Application No: LU/280/17/PL

Recommendation Report for Planning Permission

LOCATION: General Henrys
31 Horsham Road
Littlehampton
BN17 6BZ

PROPOSAL: Conversion of existing building to form 5 No. dwellings with associated cycle & refuse stores, parking & landscaping with dormers to north & south elevations.

Proposed Conversion Elevations

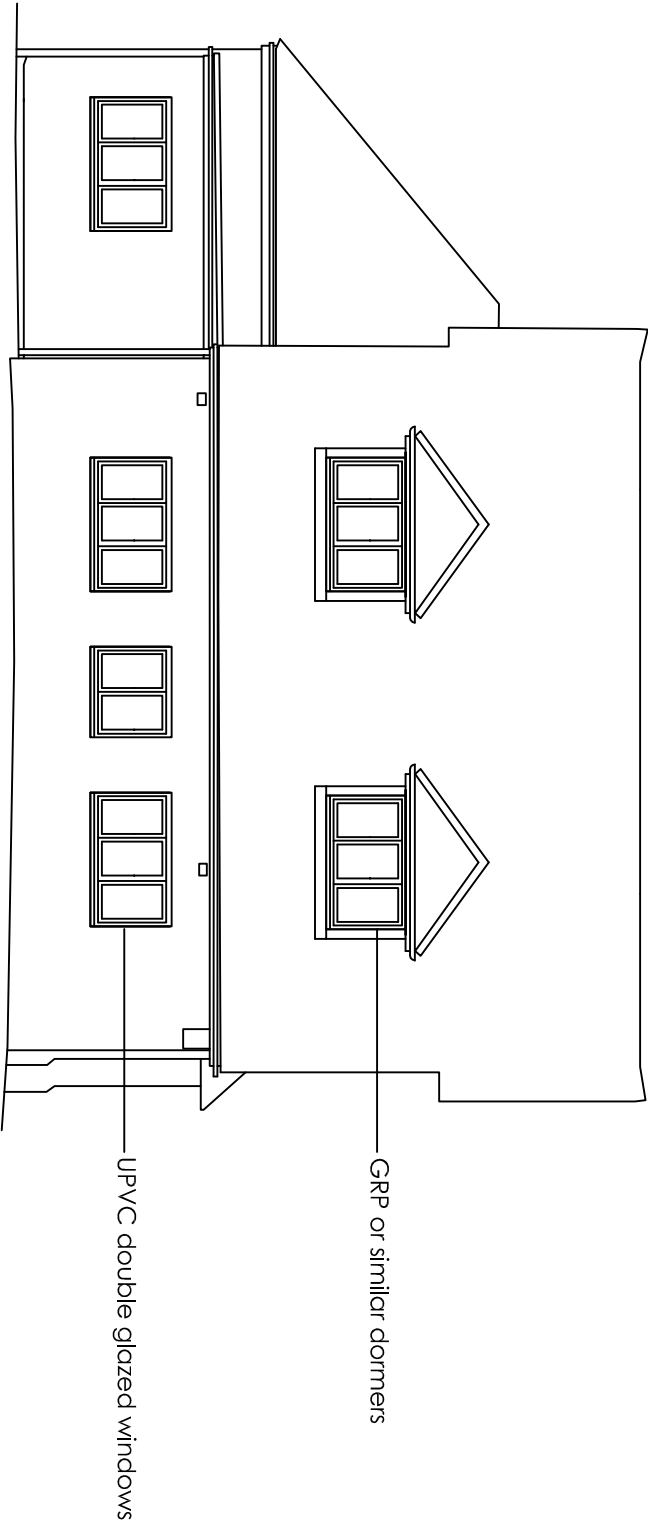
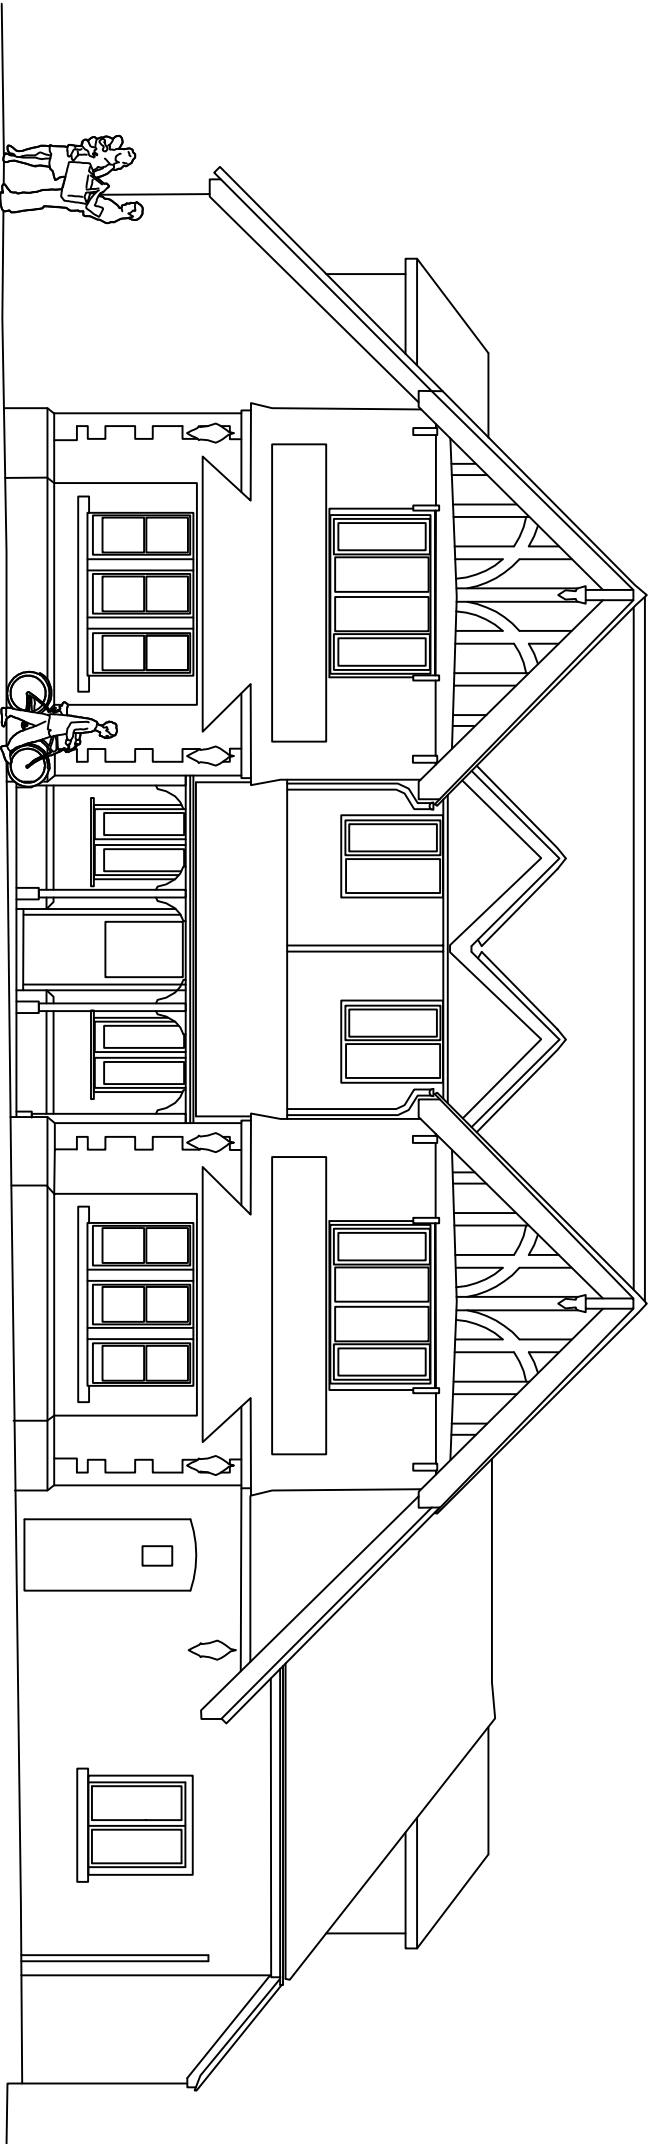
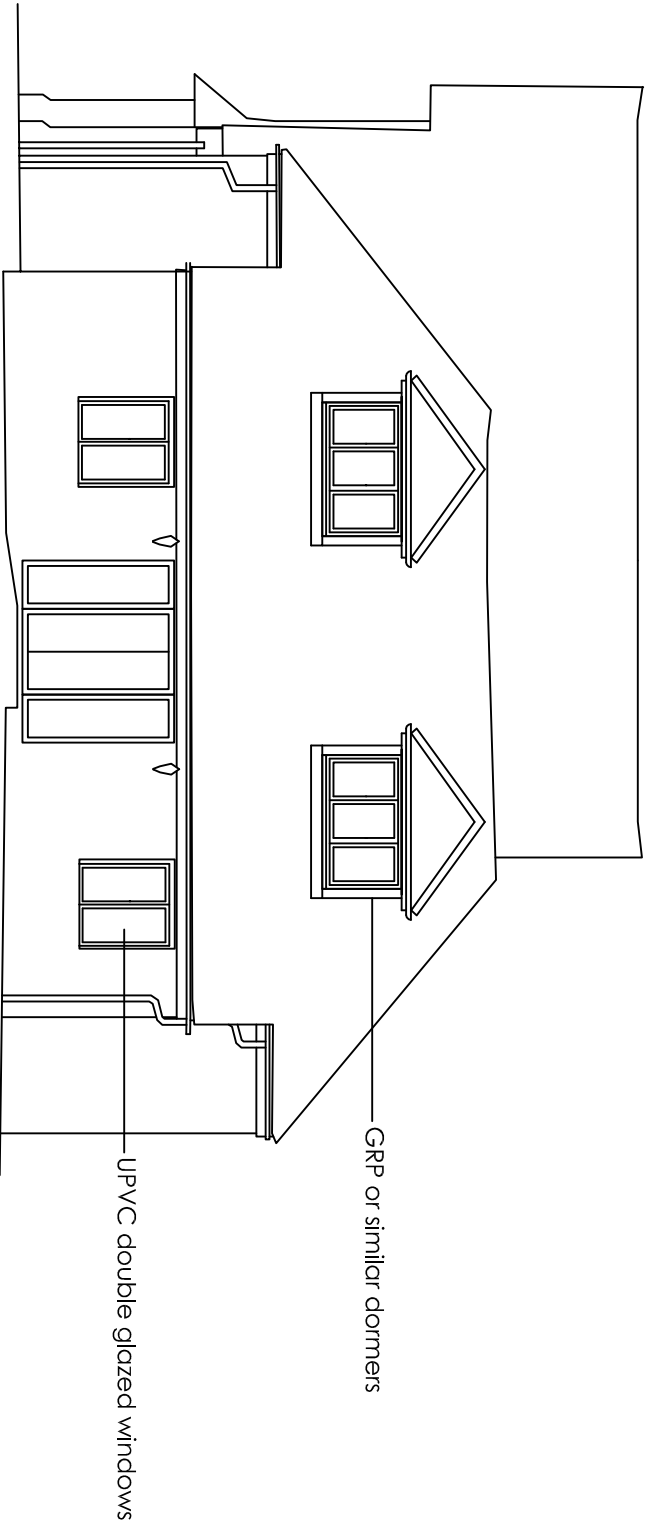
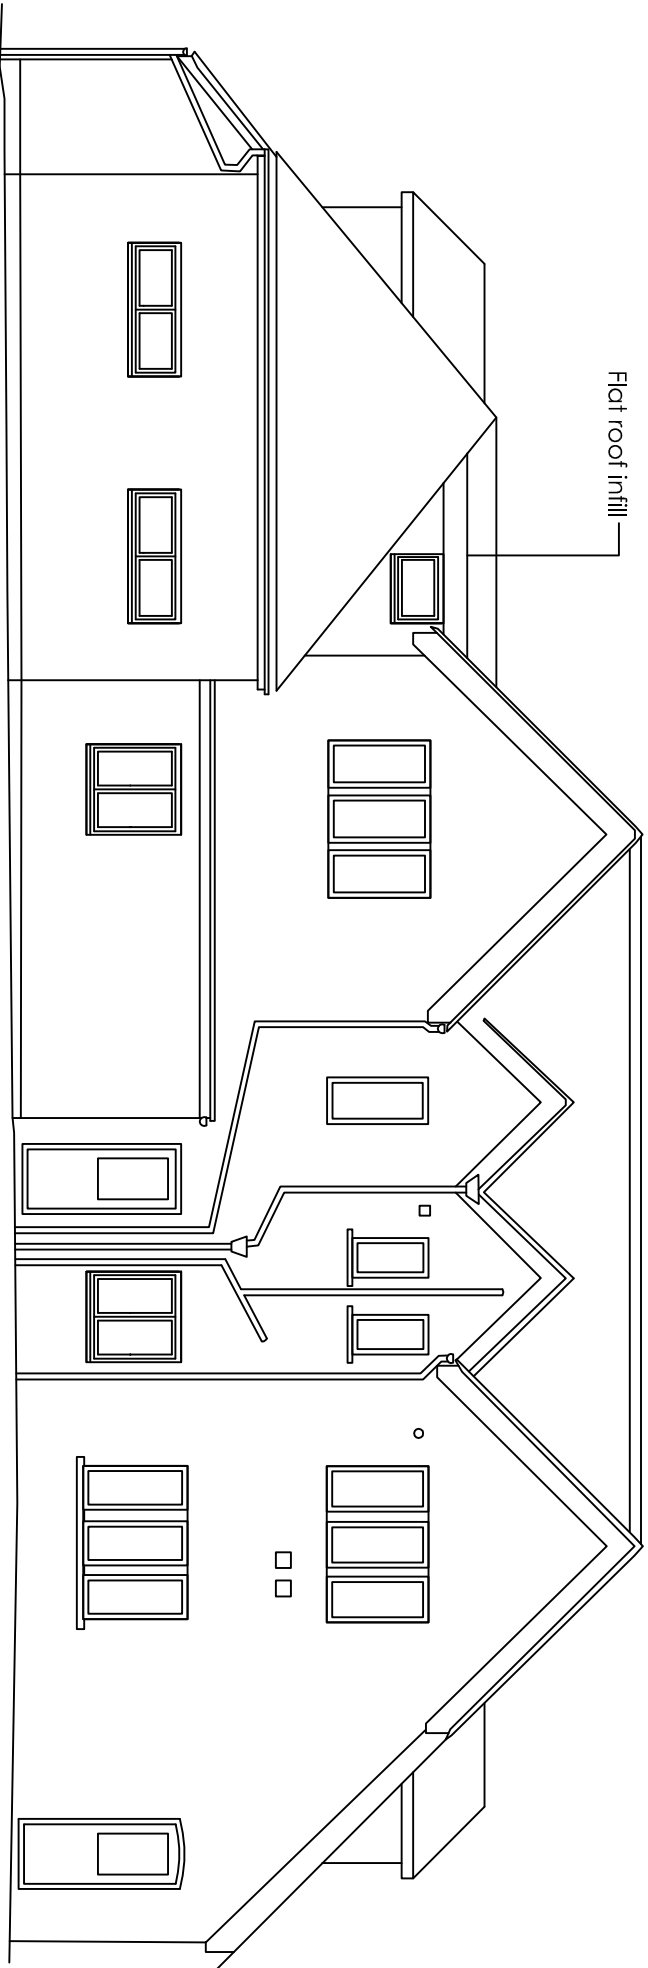
Reason for Update/Changes:
Substitute plans received showing cross sectional detail and velux windows.

The proposed dormer windows on the northern elevation of the building will be located approximately 10.3m from the southern boundary of the rear garden of 33 Horsham Road. This is not considered to be a sufficient distance to prevent direct and unacceptable overlooking into the rear garden of number 33 and a condition is therefore proposed to overcome this harm.

Officers Comment:
Noted. These demonstrate that rooms in unit 5 will benefit from natural light and ventilation.

- 3 The two dormer windows on the north elevation of the building shall at all times be glazed with obscured glass and fixed to be permanently non-opening up to 1.7m above ground floor level.
